City of Albuquerque

December 20, 2000

RE: GRADING & DRAINAGE PLAN FOR DESIGN CENTER NORTH, 8801 JEFFERSON,
NE (C-17/ D02A26B) ENGINEER'S STAMP DATED OCTOBER 23, 2000,
SUBMITTED FOR BUILDING PERMIT AND SO 19 APPROVALS

DESIGN CENTER NORTH GRADING & DRAINAGE PLAN

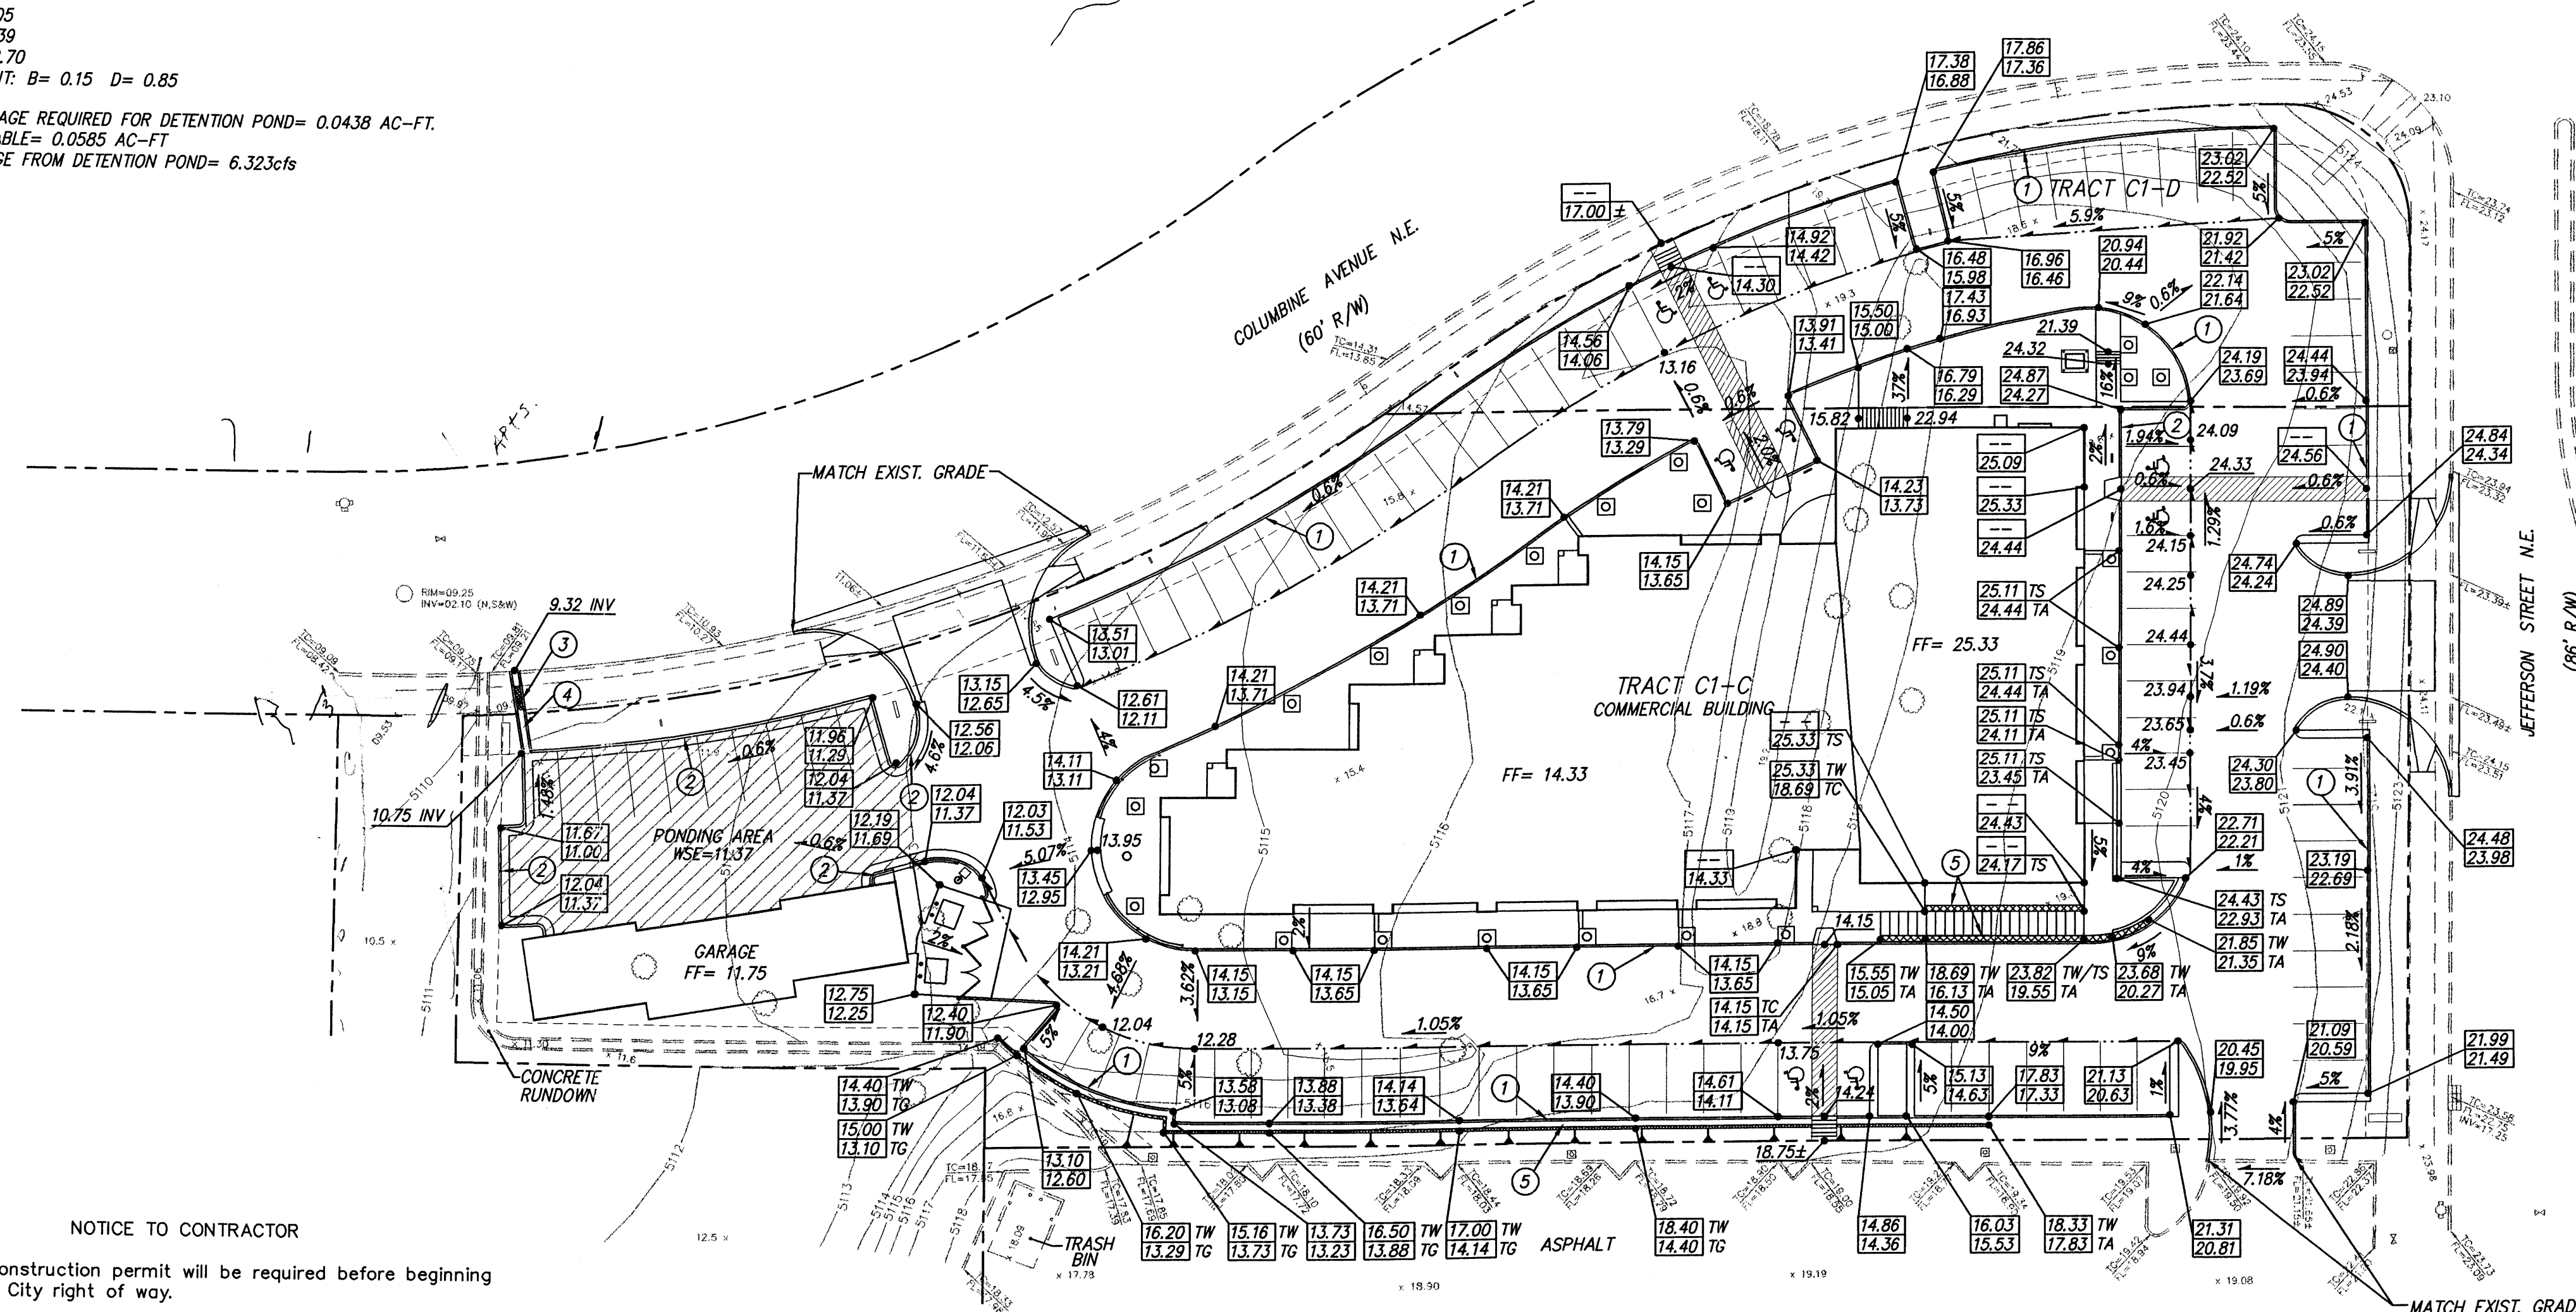
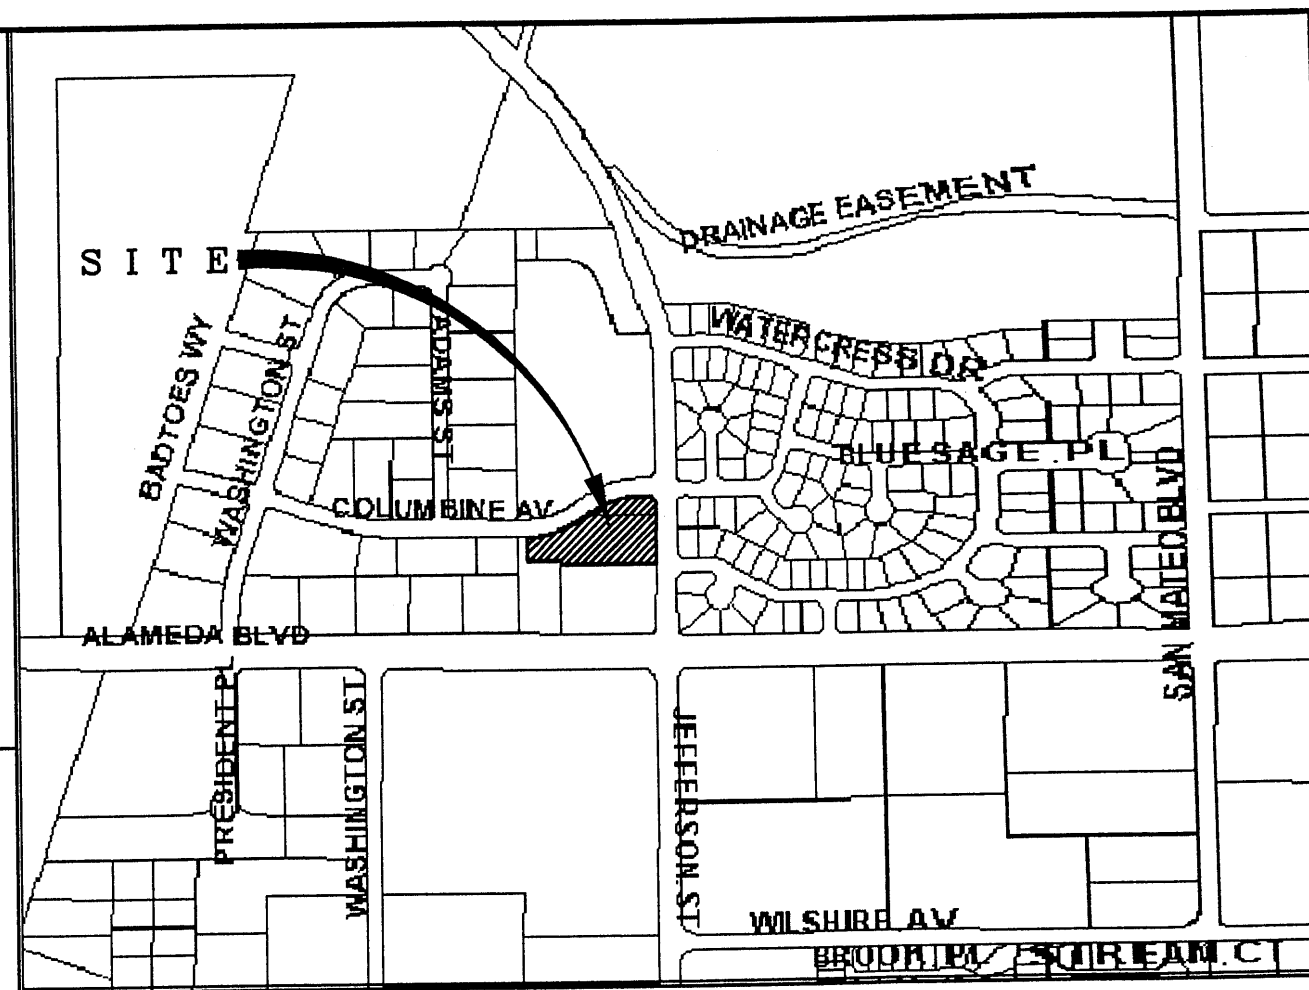
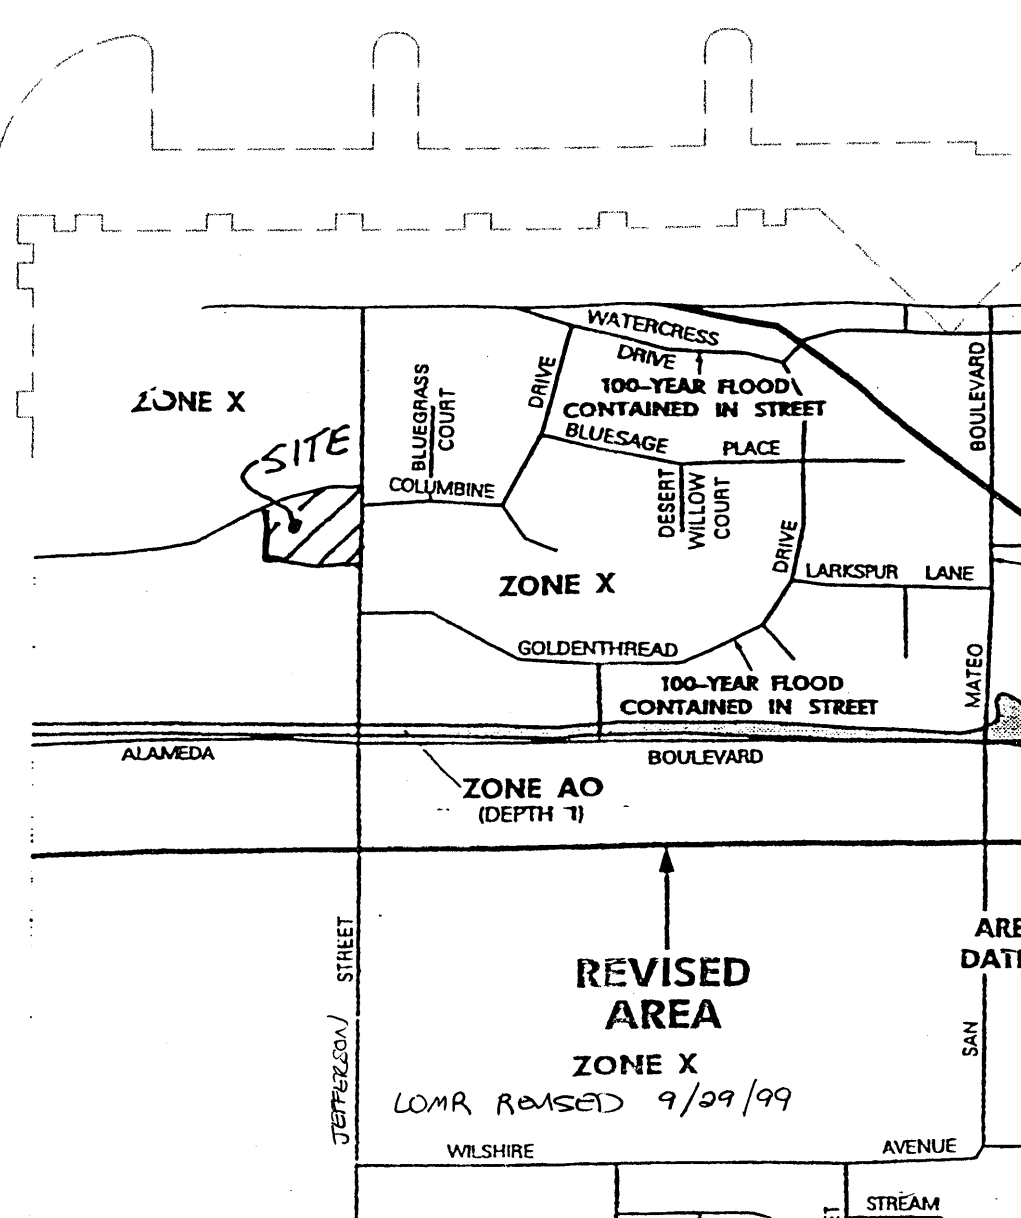
Correct Key Note 4. It also should have a 2-foot wide rundown to match the sidewalk culvert. Note that only the Inspector's Signature is now required for sign-off at the completion on construction.
